Planning - Case Comments

Project Number: PR-2019-002380

Project Name: 10000 Central Ave SW

Request: Site Plan Administrative DFT

A2.6

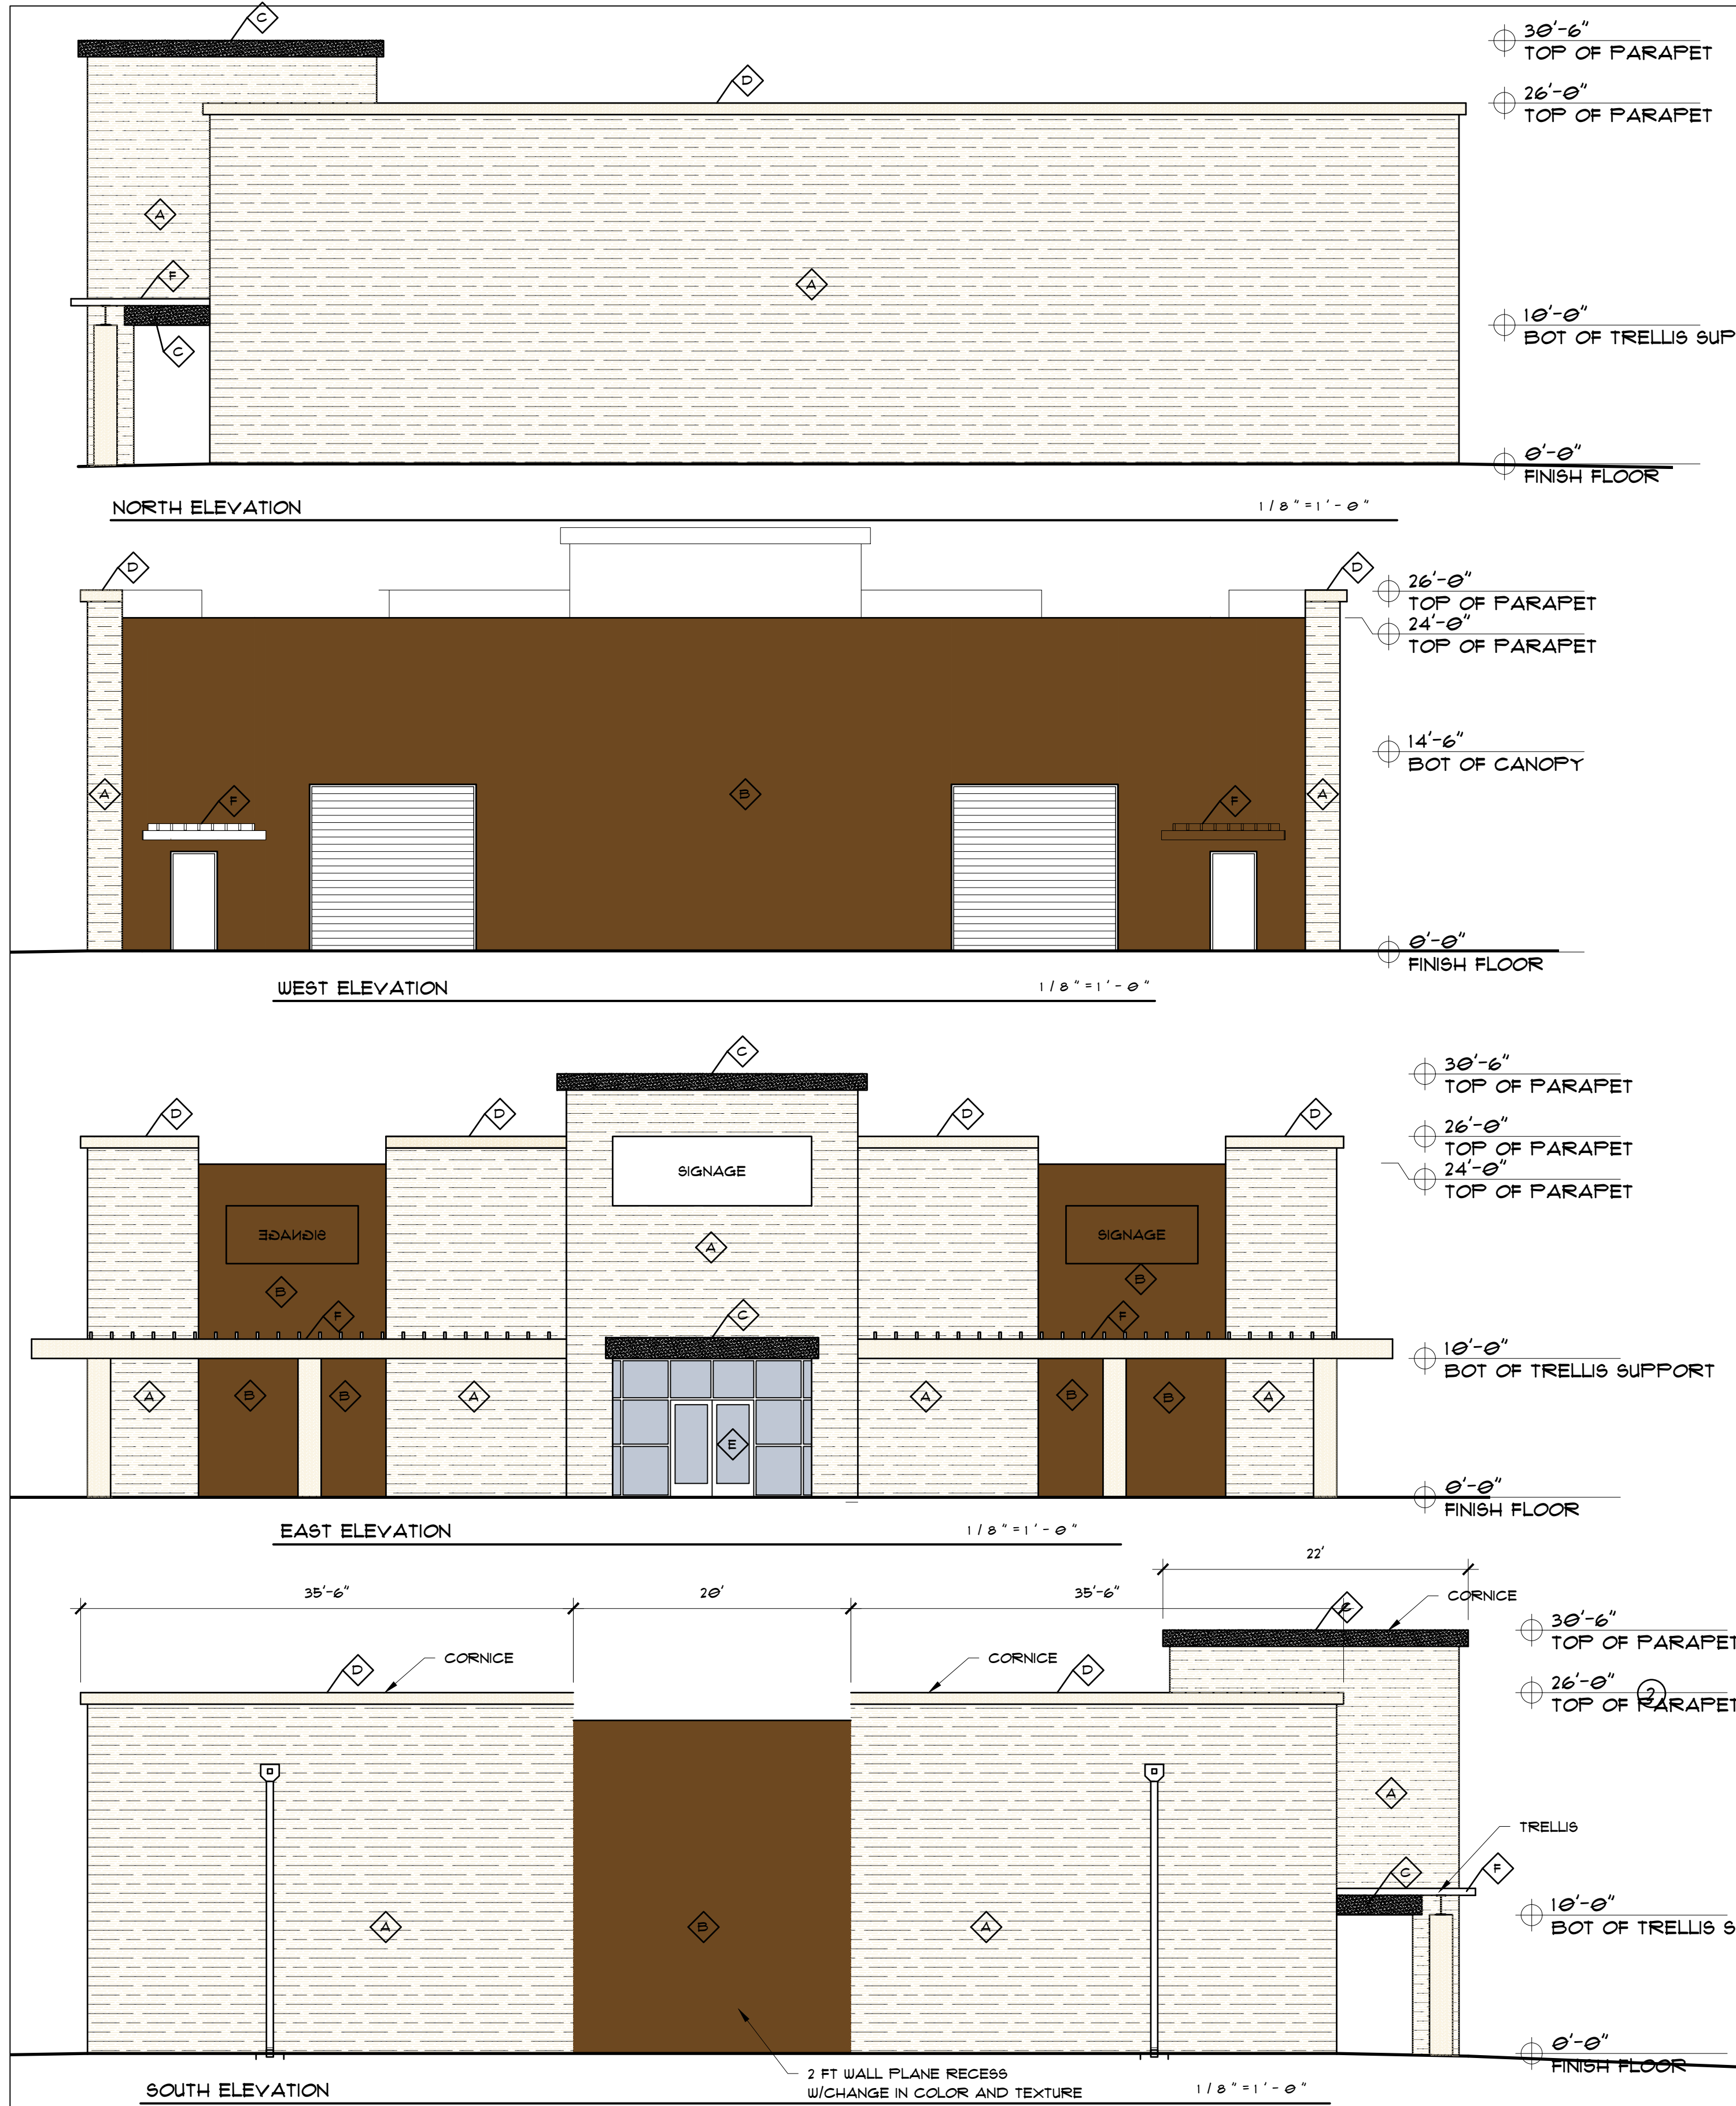
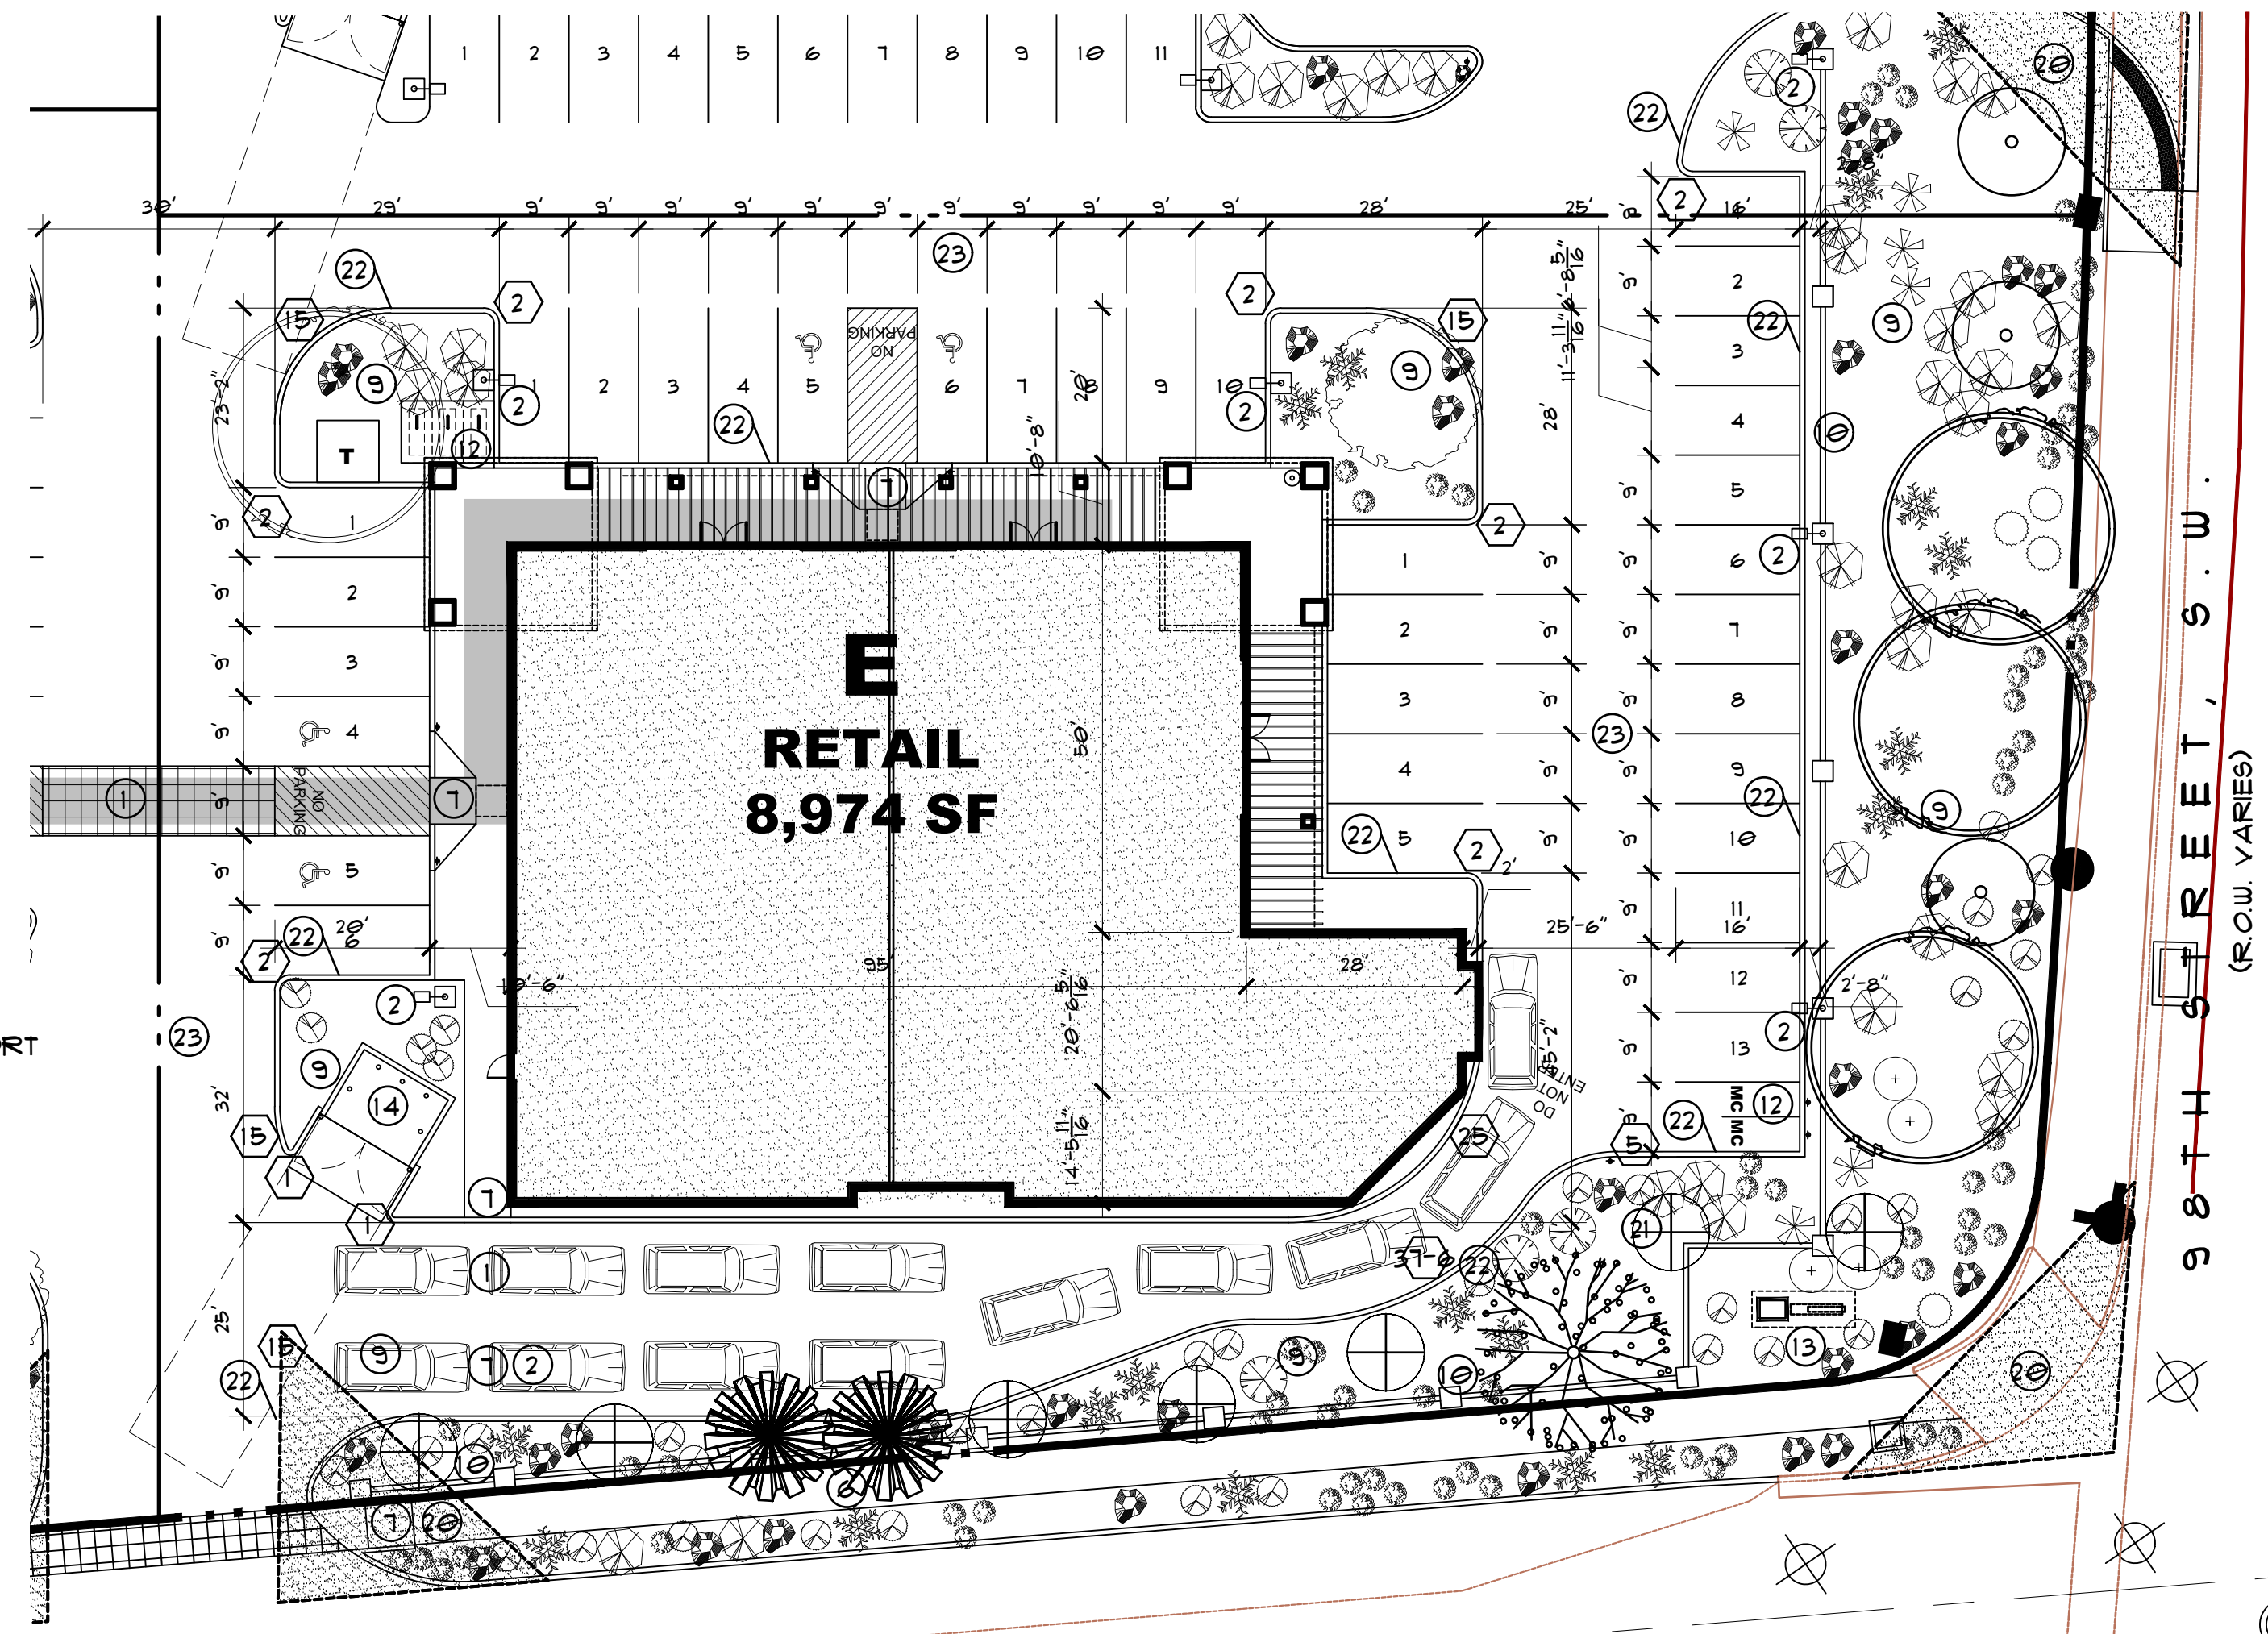
1. Drive-thru lane for revision on Building E must meet requirements for screening from public right-of-way, as per IDO 5-5(I)(2)(a). We have added a screen wall to the south of Bldg E, see A1.1 and A2.6
2. Revised loading area on Building F must meet screening requirements for Loading, Service, and Refuse areas adjacent to residential development, as per IDO 5-6(G)(3). These areas “shall be located where they are not visible from the streets...or from adjacent properties with low-density residential development to the maximum extent practicable,” as per IDO 5-6(G)(3)(d). We have added a screen wall to the south of Bldg. F2, see A1.1 and A2.7, note 10a.
3. Code Enforcement has no further comments at this time, and no objections.

- In regards to Building E, it appears that the drive-thru window is on the East side of the building facing 98th which is also the primary entrance for this retail grocery store. Please confirm if this is the intent of the drive-thru location. Consider relocation if it is in conflict with 5-5(I)(1)(a) **Screen wall has been added to the south of queueing**
See sheet A2.6
